**Eastern Creek Business Hub Modification (SSD-5175-MOD-5) & Retail Centre Lot 1  
(SSD-8858)**

**Response to Submissions**

I refer to the Response to Submissions (RTS) submitted for the Eastern Creek applications SSD-5175-MOD-5 and SSD-8858. The Department is requesting you provide additional information before accepting the RTS, as follows:

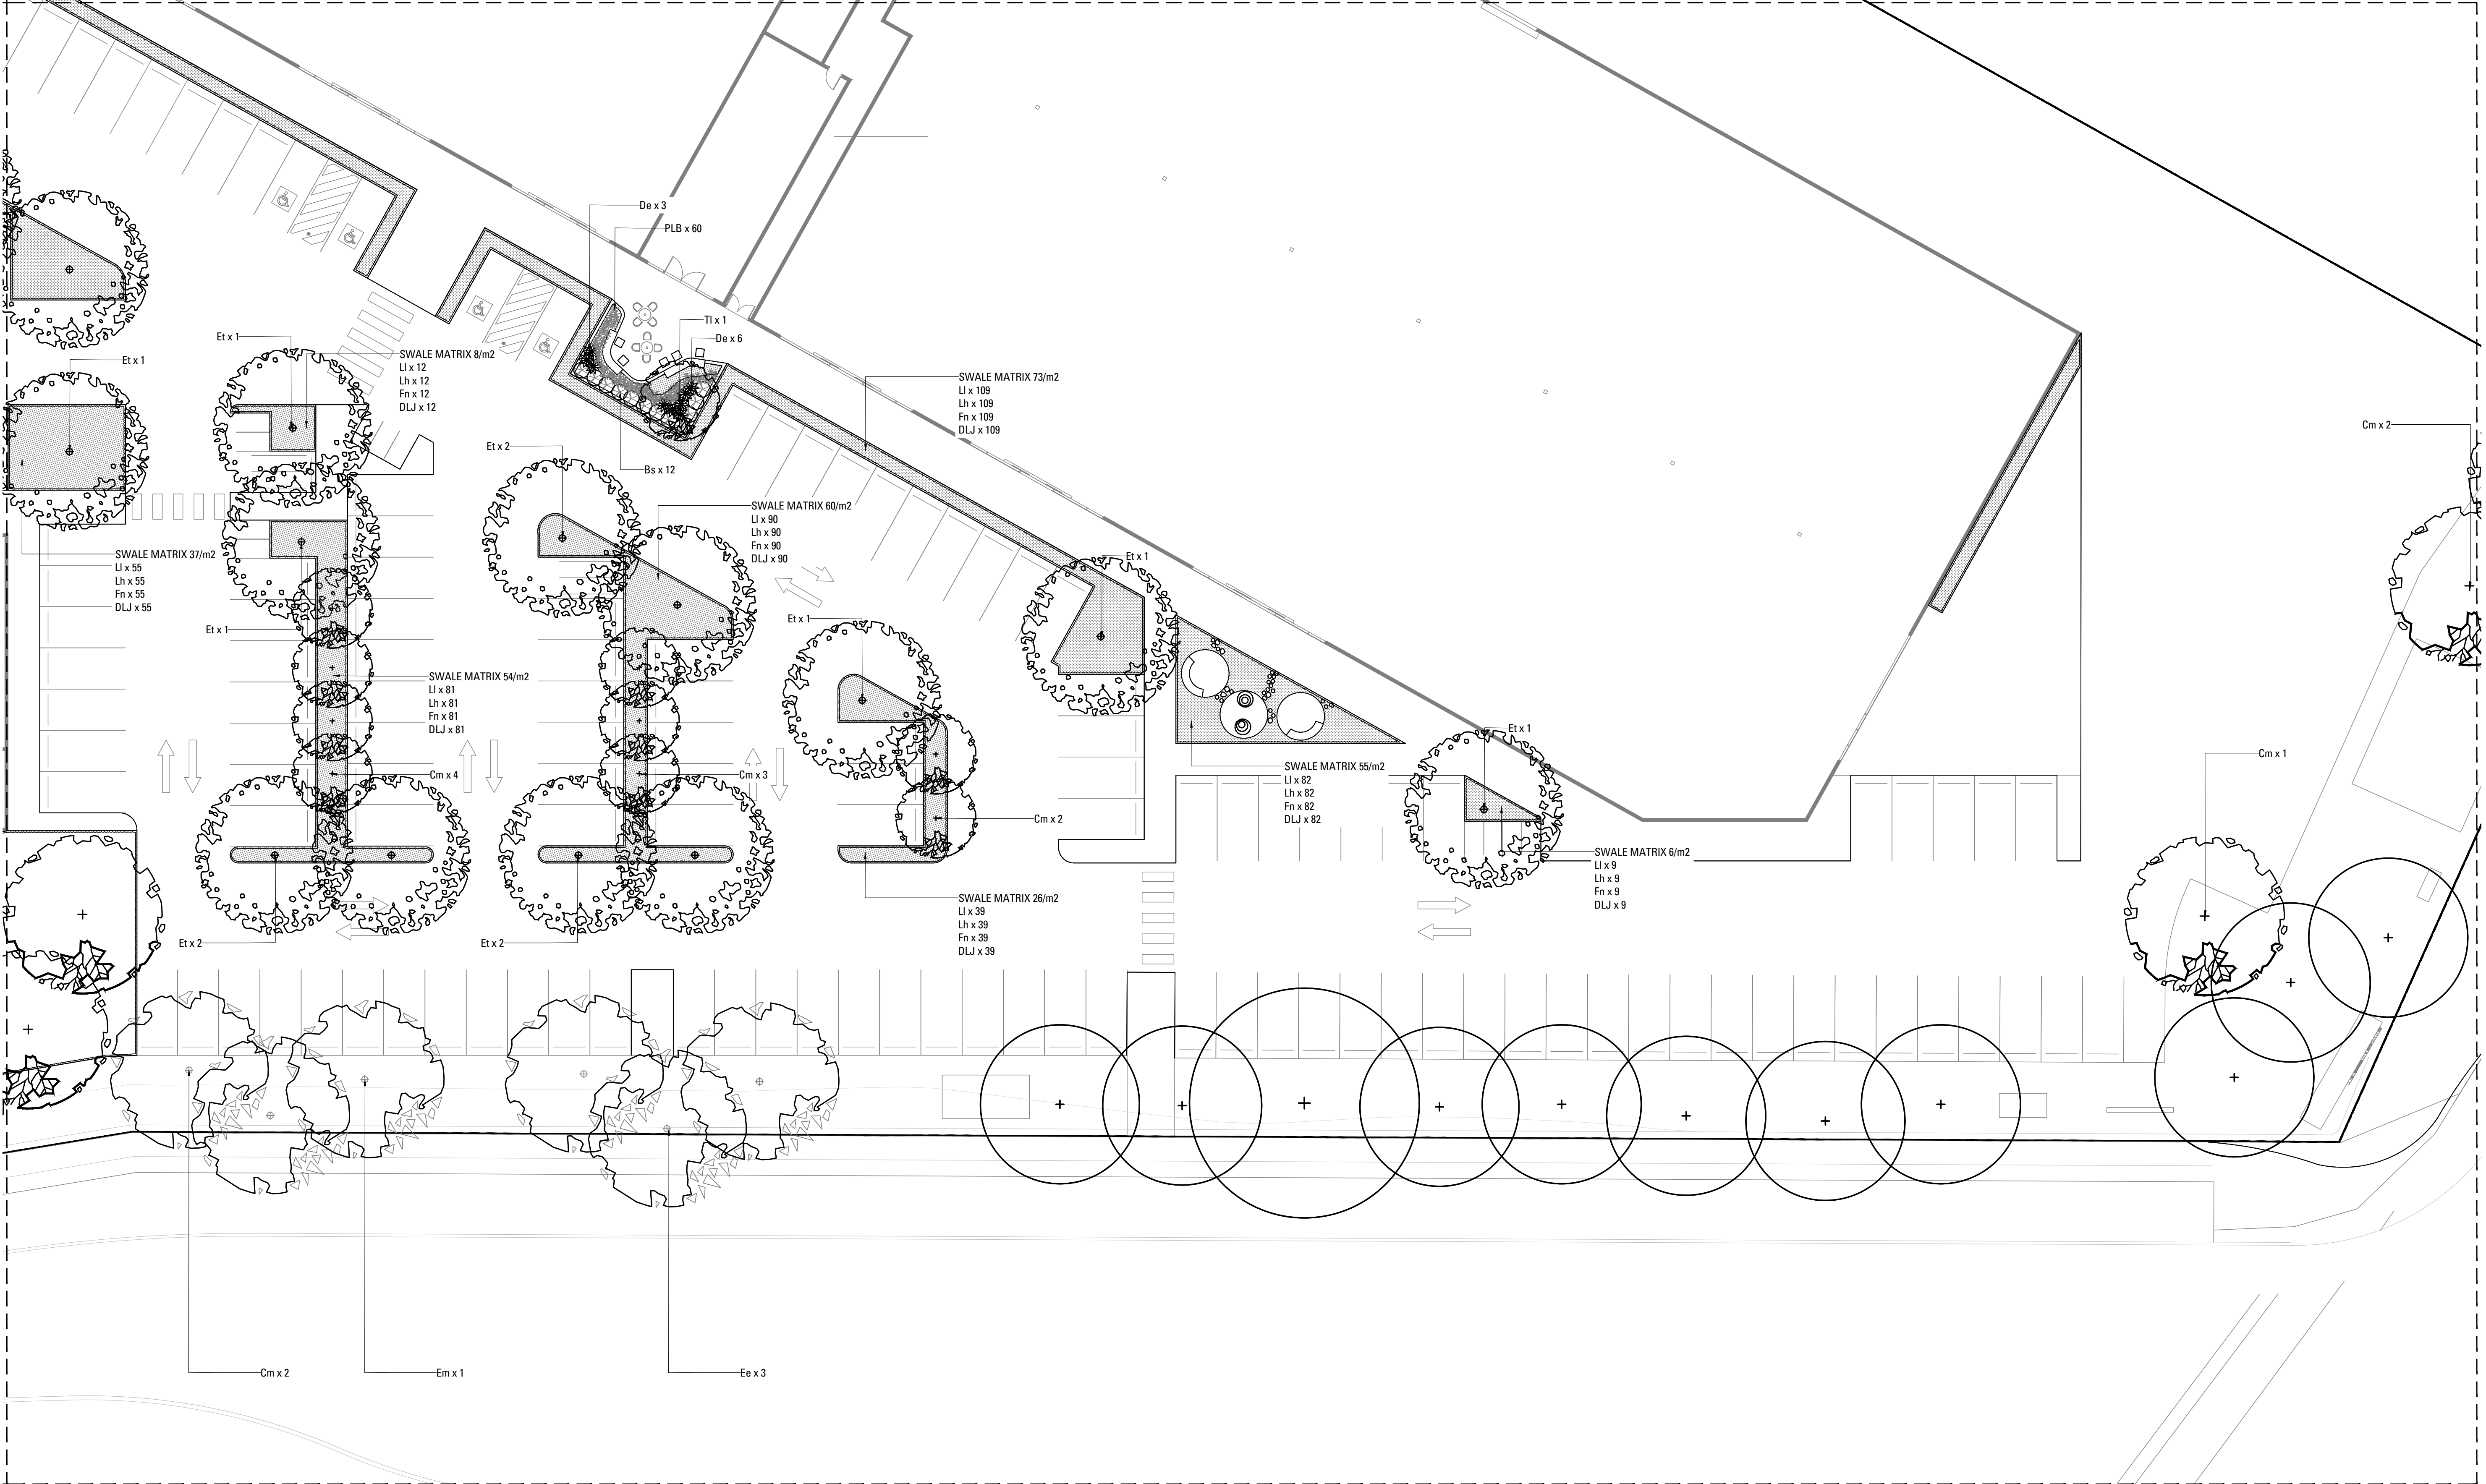
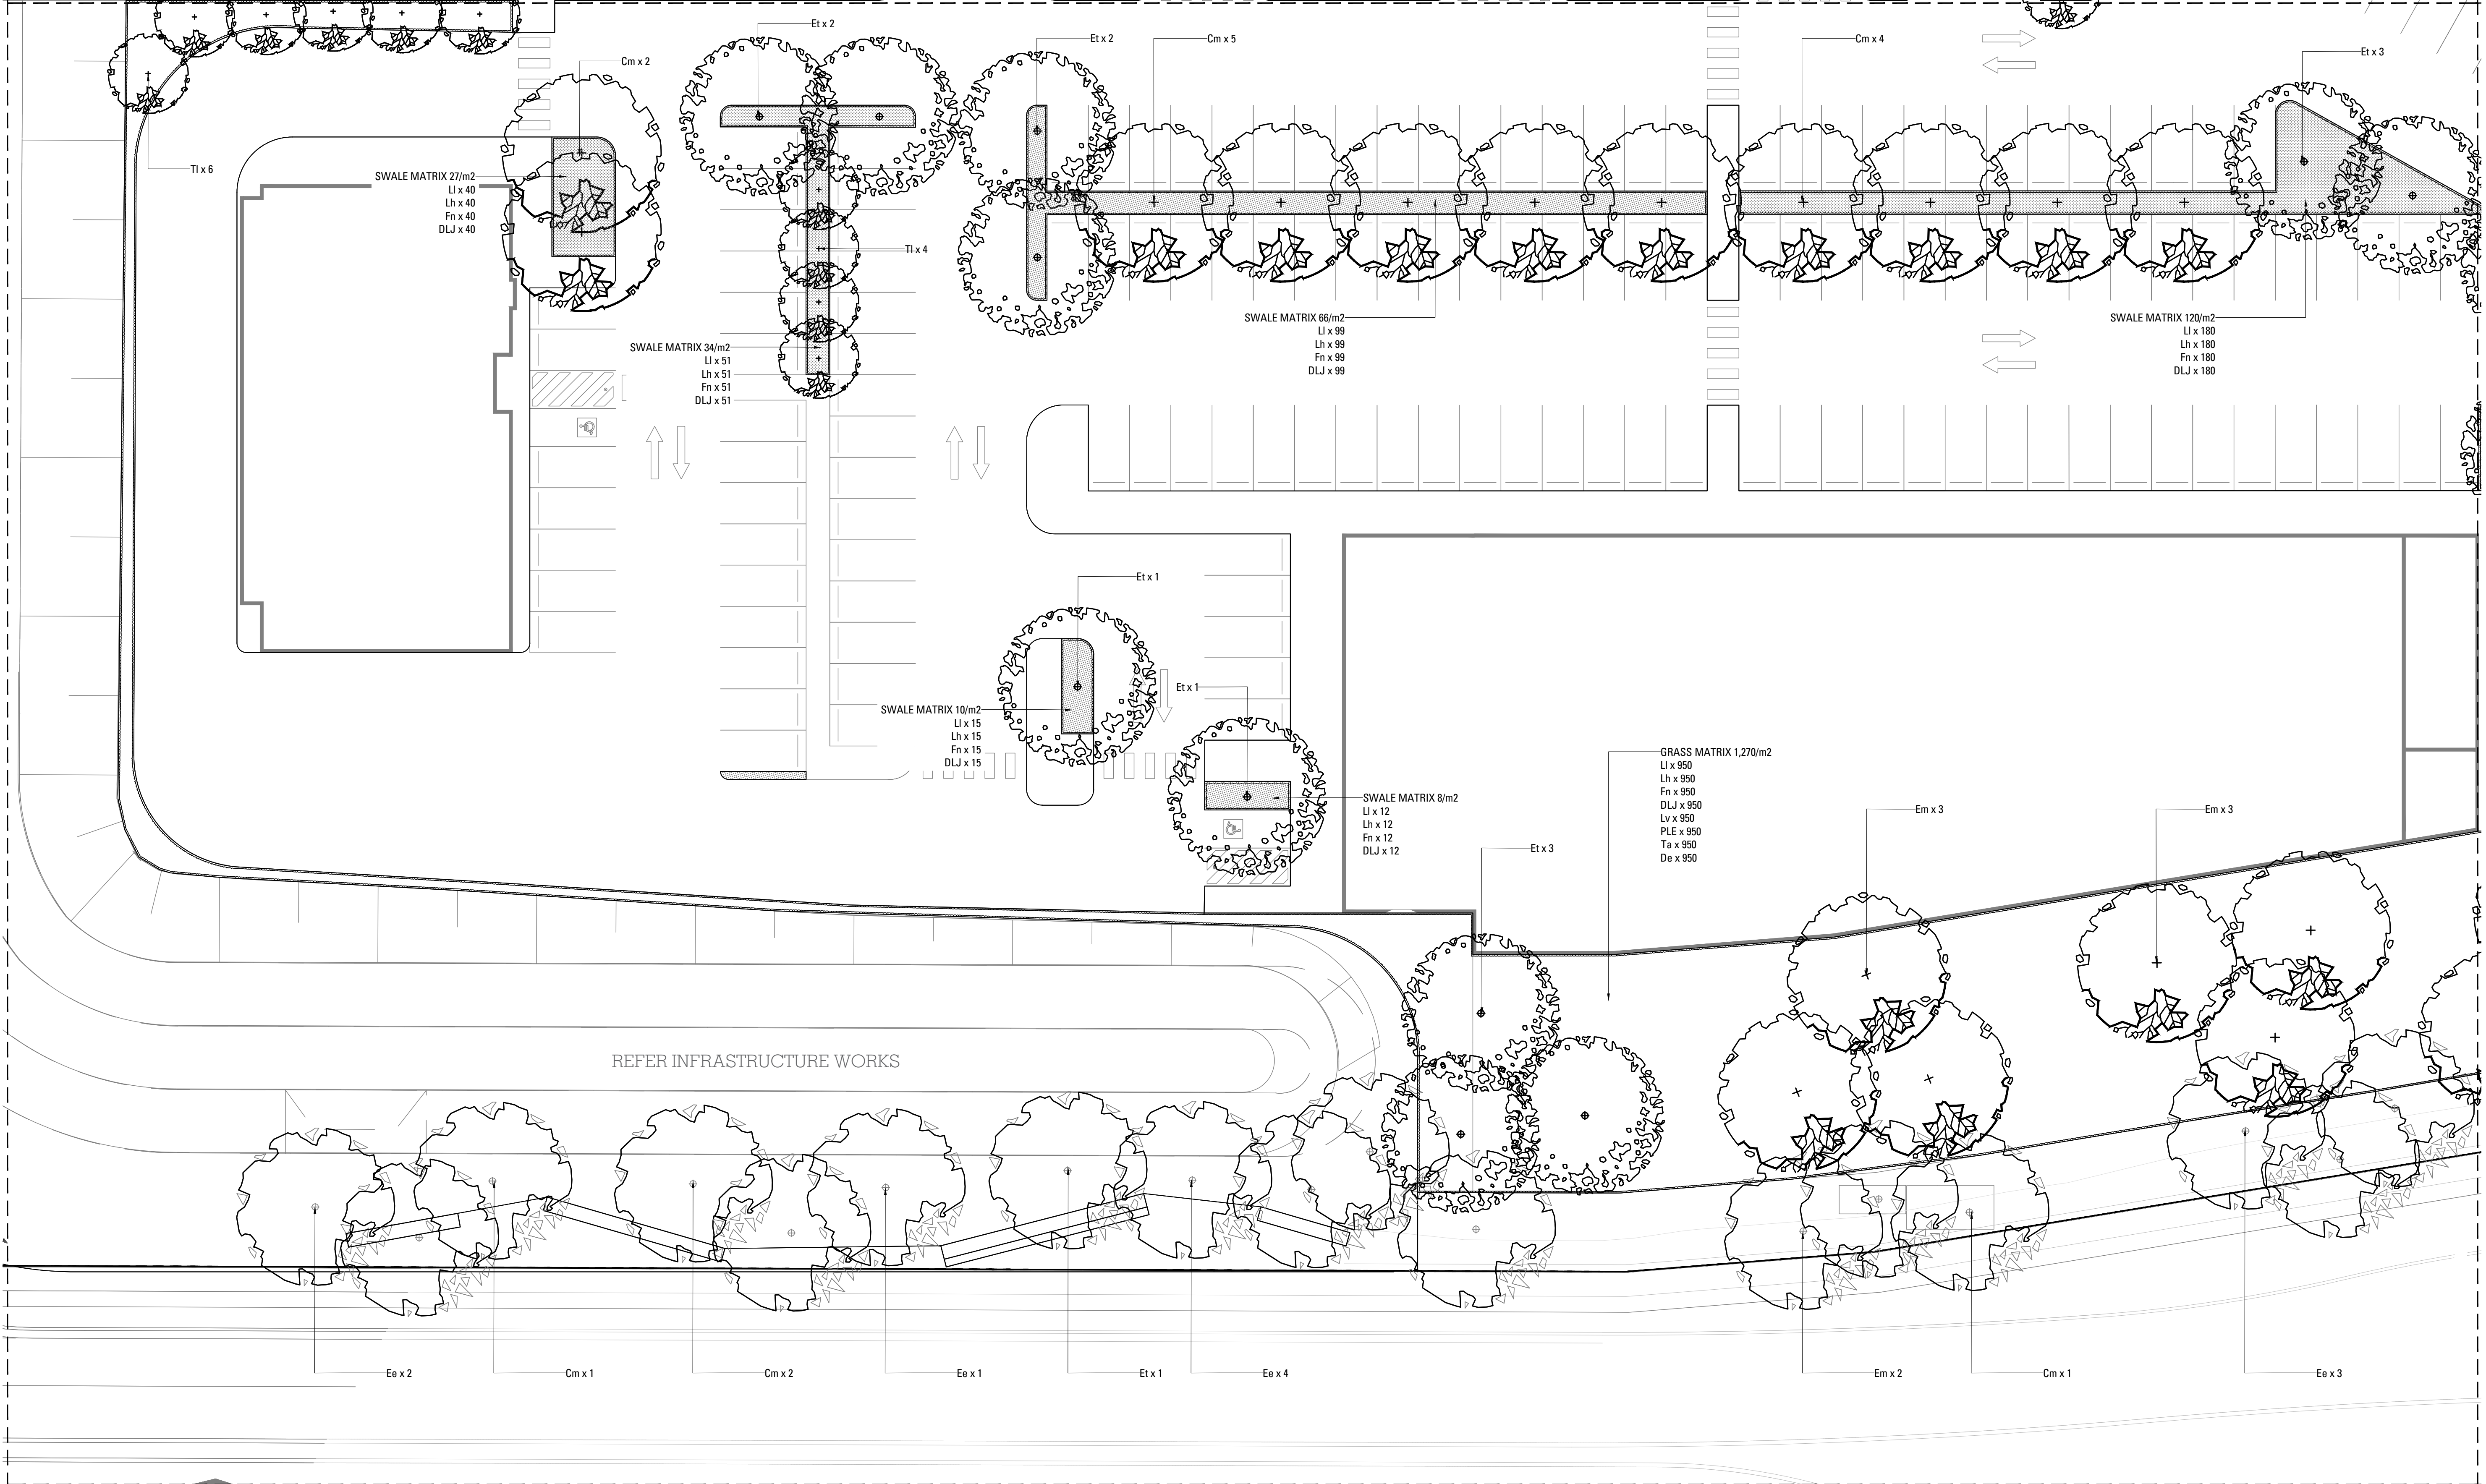
- Identify on the proposed site plan DA04, the three car spaces relocated from the front of Major Tenancy 1
- The amended Landscape Plan has removed the references to the existing trees to be retained on pages 7, 8, 12, 14 and 17 of the document. Re-instate the reference to the retained trees on these pages.
- Provide plan DA06 Elevations Stage 2, as it is missing from the architectural plan set submitted
